DECISION DELEGATED TO HEAD OF PLANNING

Application No:	H17-0811-22	Applicant:	Ashley King Developments Ltd
Proposal:	Details of archaeological investigation, flood risk assessment and drainage strategy measures, proposed boundary treatments, publicly accessible open space, protected species report, open space management plan, storage and disposal of refuse and recycling, protection of trees, protection of existing hedge, swift nest bricks/boxes, external materials, Sunnydale Close access, gas and electricity external boxes, construction management, estate road phasing and completion plan, surface water disposal and design & location of road/footpath lighting. (Conditions 3, 4, 6, 7, 8, 9, 10, 11, 12, 13, 14, 15, 16, 17, 18, 19, 20, 21 and 22 of H17-1187-21)		
Location:	Land Off Sunnydale Close Surfleet Spalding		
Terminal Date:	20th January 2023

CONDITION COMPLIANCE. Details of archaeological investigation, flood risk assessment and drainage strategy measures, proposed boundary treatments, publicly accessible open space,

SCALE: AS_SHOWN@A1 DRAWN: GB
DATE: AUGUST.2022 REVISION: /
DRAWING No: 118-TP-01

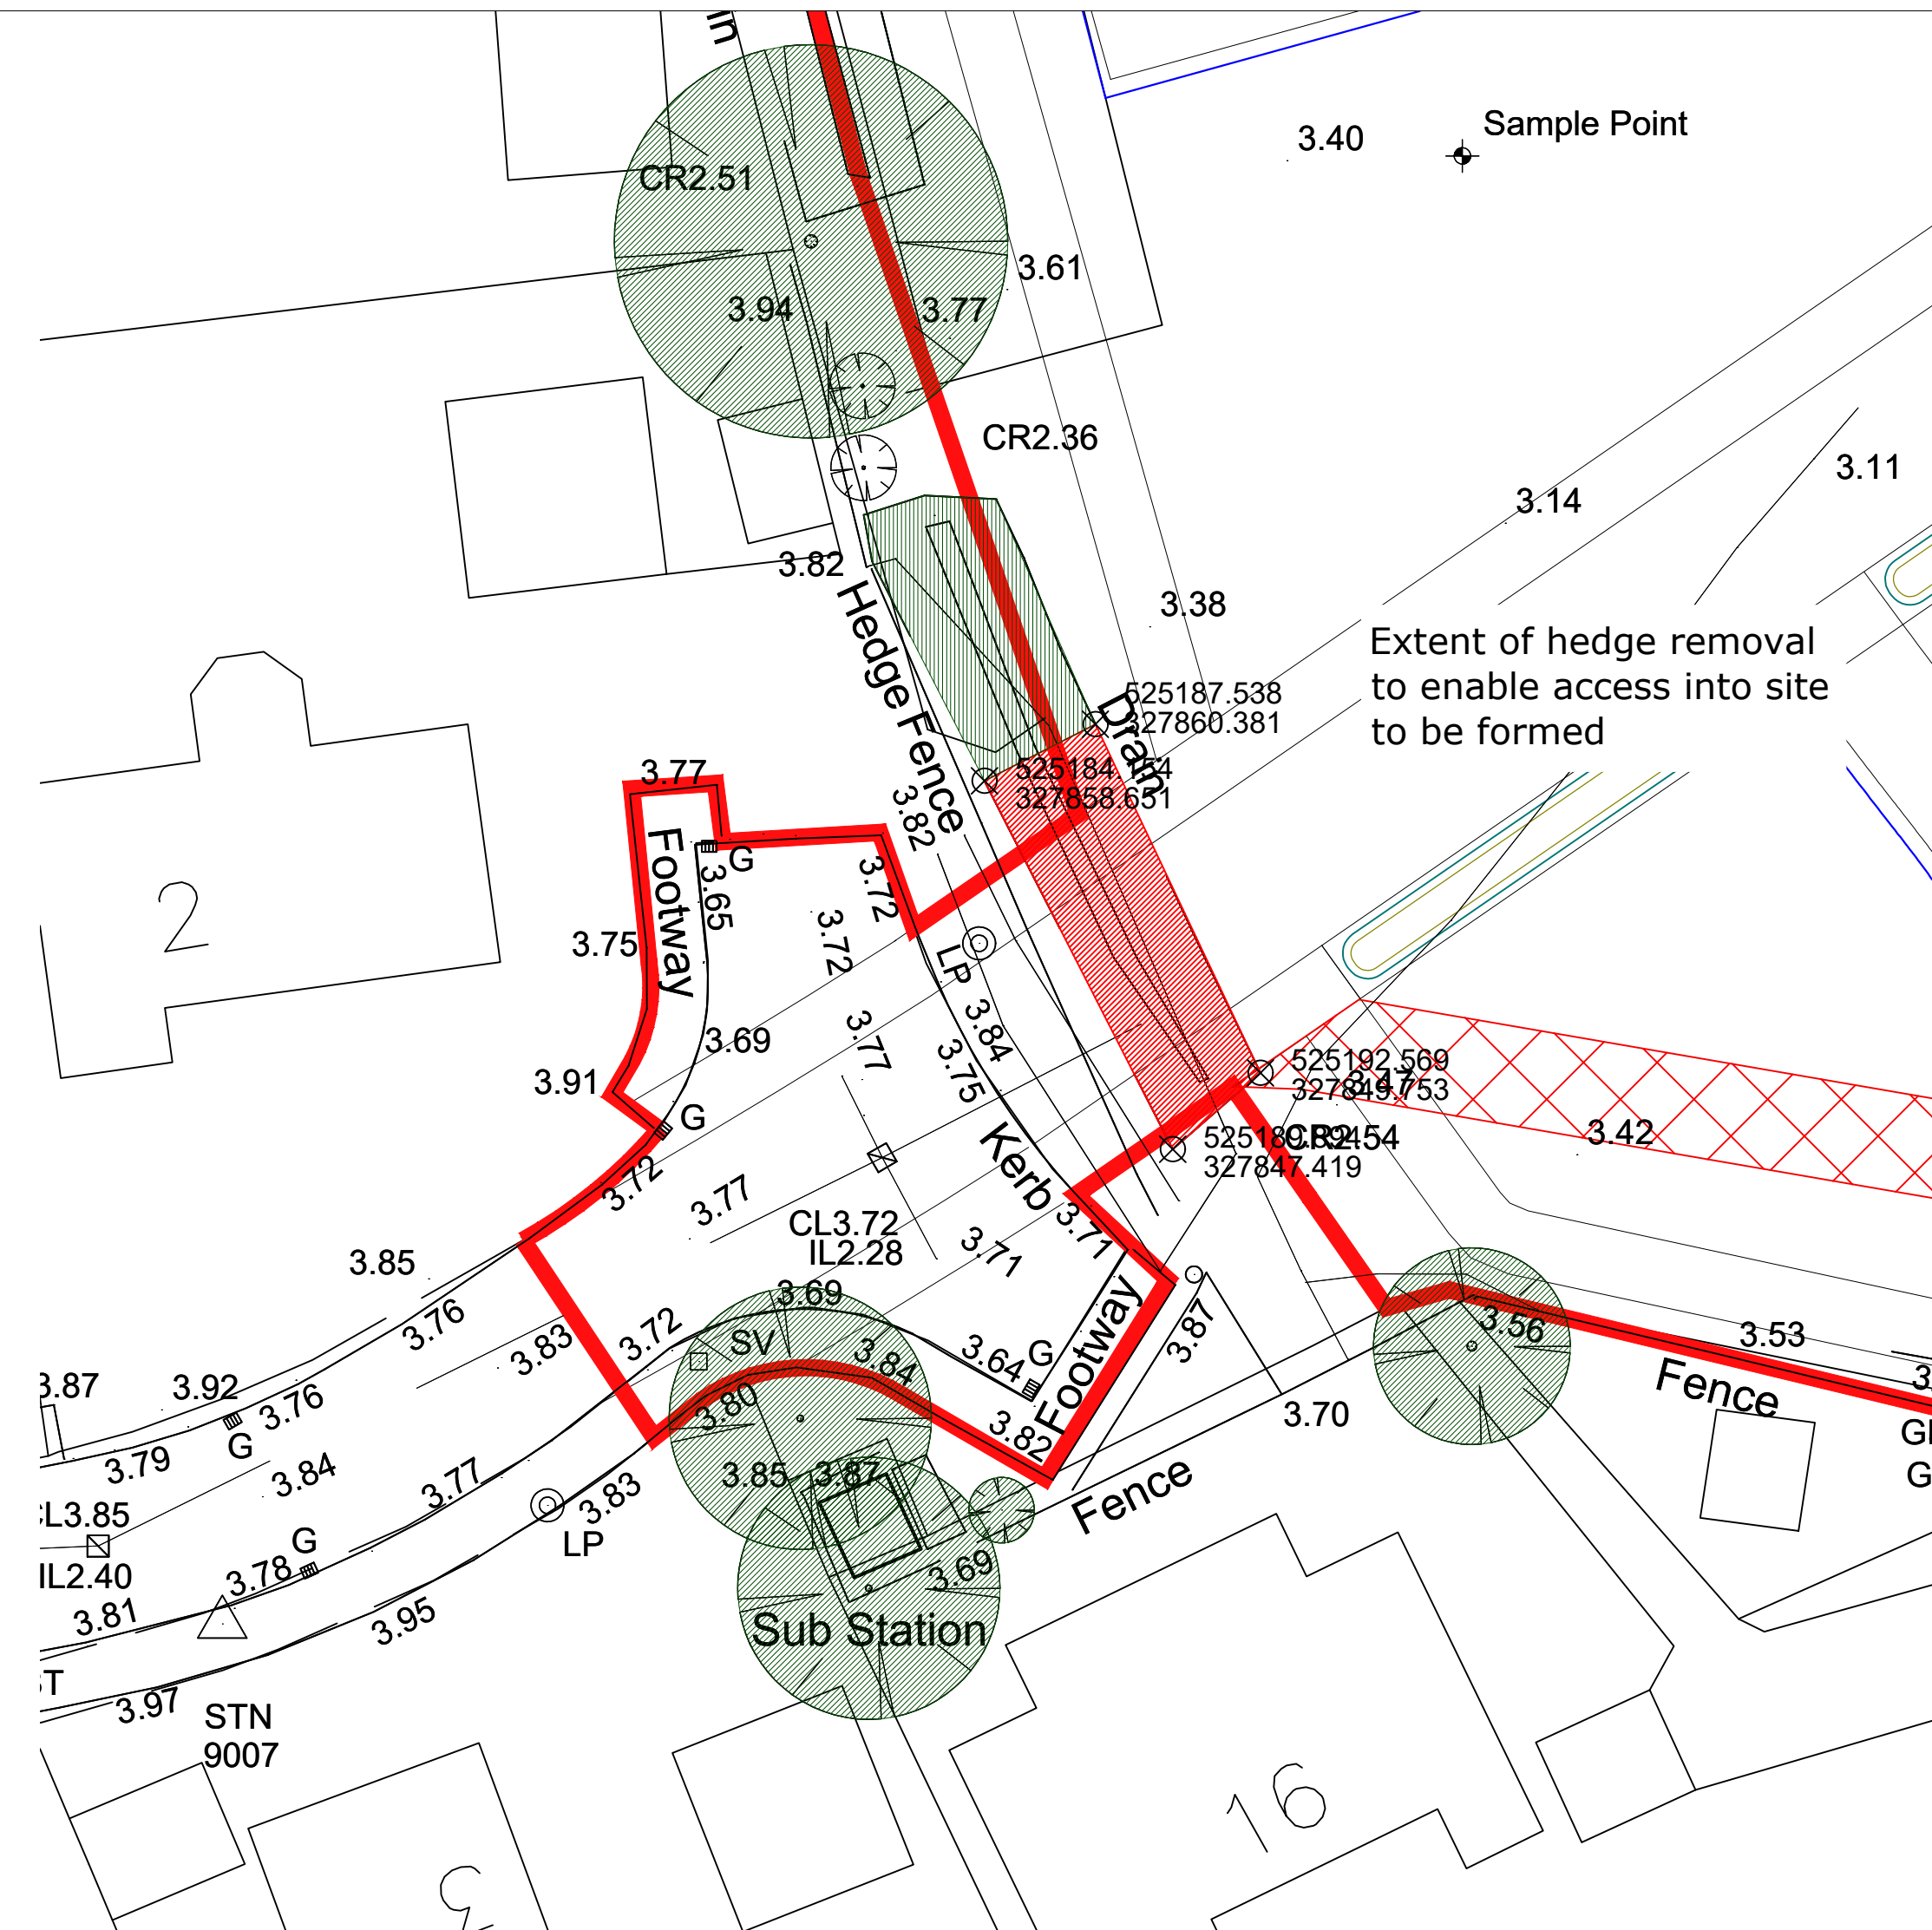
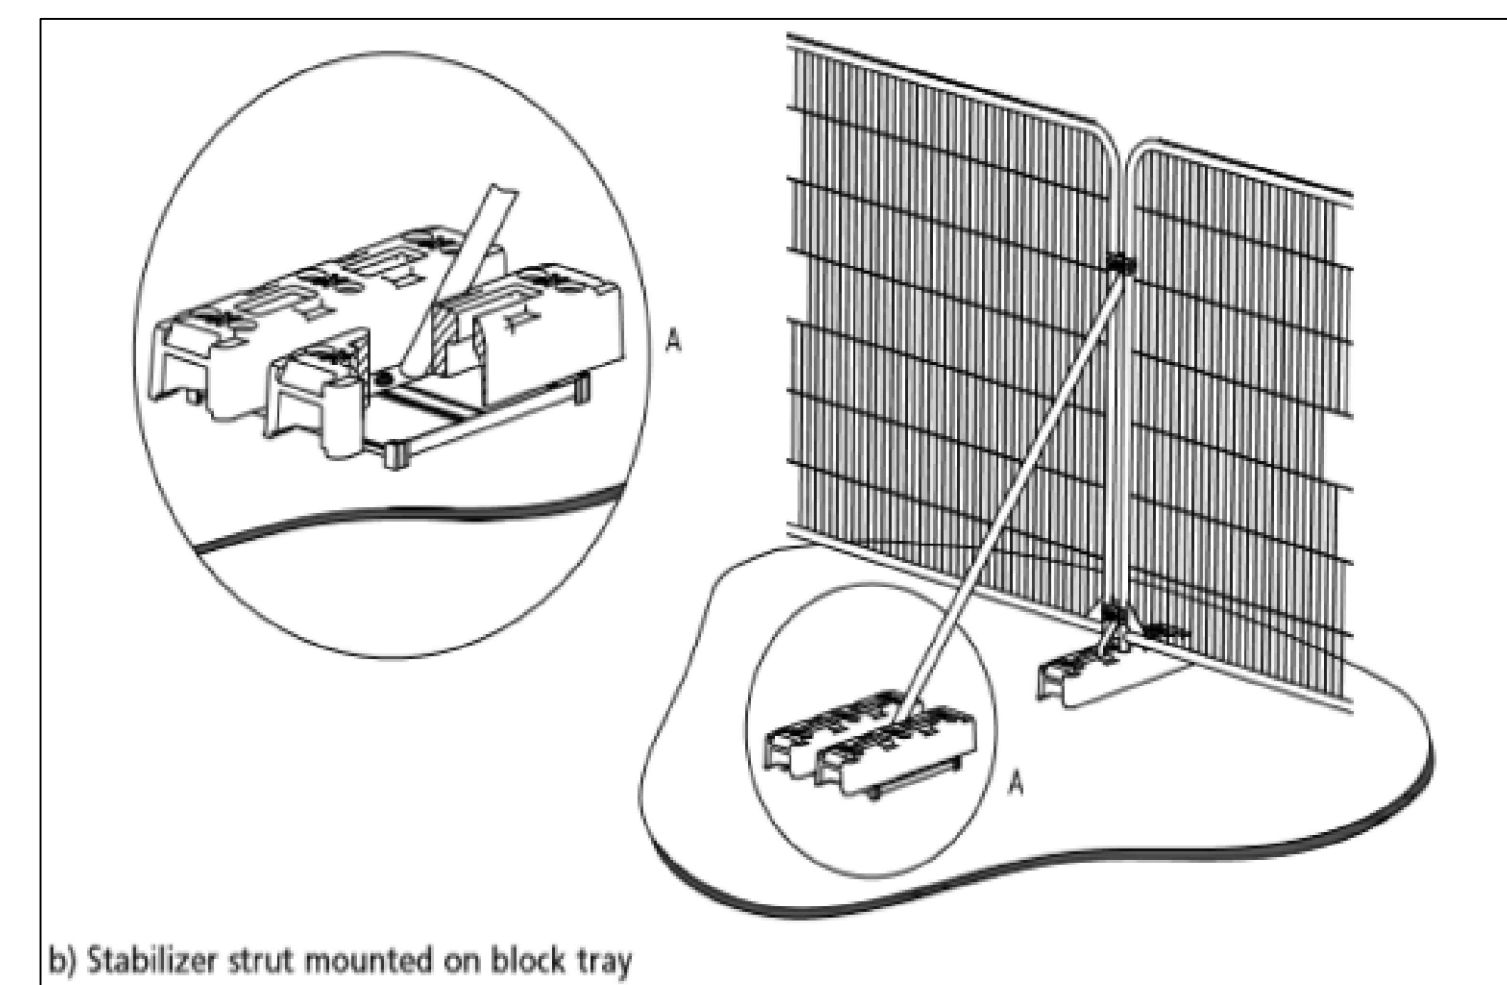
Tree Protection Plan 118-TP-01. In enlarged section of plan, tree above that with Sub Station written beneath its canopy.

Appears to have a footway constructed within the Root Protection Area.

Is this a new footway? Can it be constructed so as to cause minimum disturbance to tree roots, using as much as possible 'No dig' methods. Presumably it will be maintained as part of the public Highway? If the advice of a suitably qualified arboriculturalist is sought at this stage in conjunction with Highway requirements, the path should be able to be constructed: a. To cause minimum disturbance to tree roots and b. To take into account the growth of the tree roots so as the pavement is not damaged by the tree roots in the ensuing years. Potentially a 'Win, win situation.

Landscape Proposals ~ 1:200@A1 ~ Sheet 2 of 2

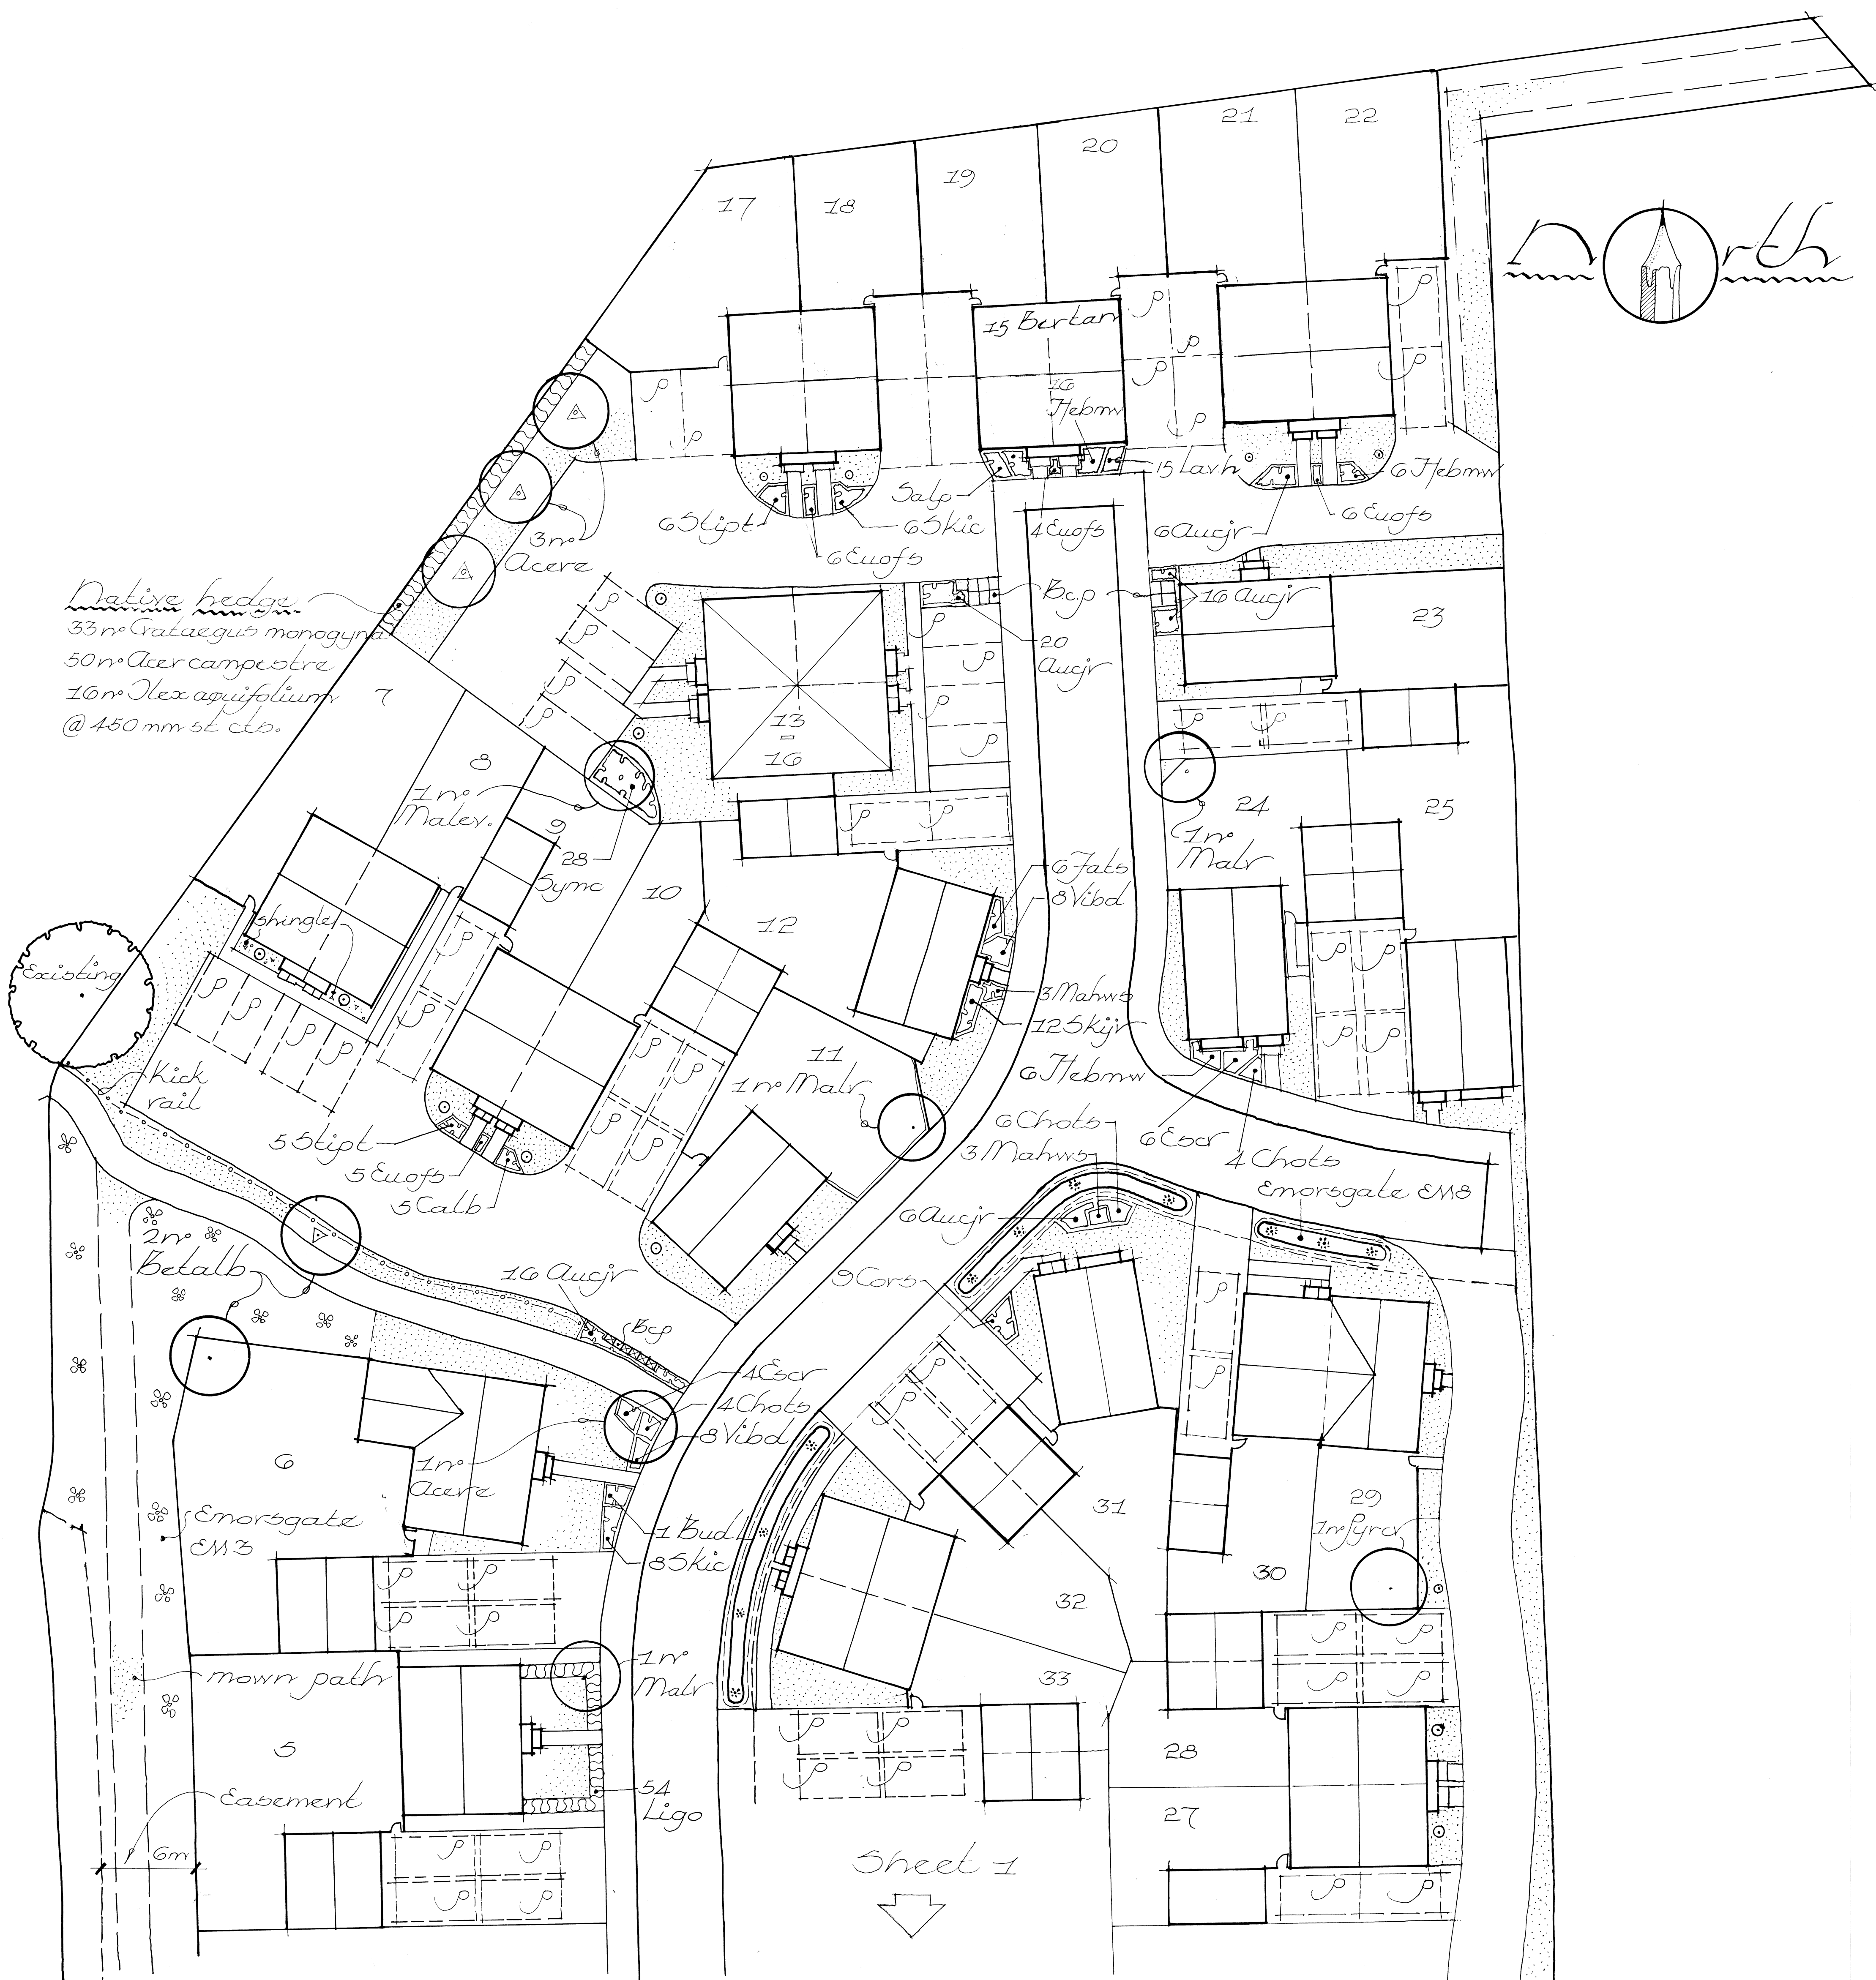
Landscaping plans. Can guess species, but could not immediately find a list/key of tree species to be certain.
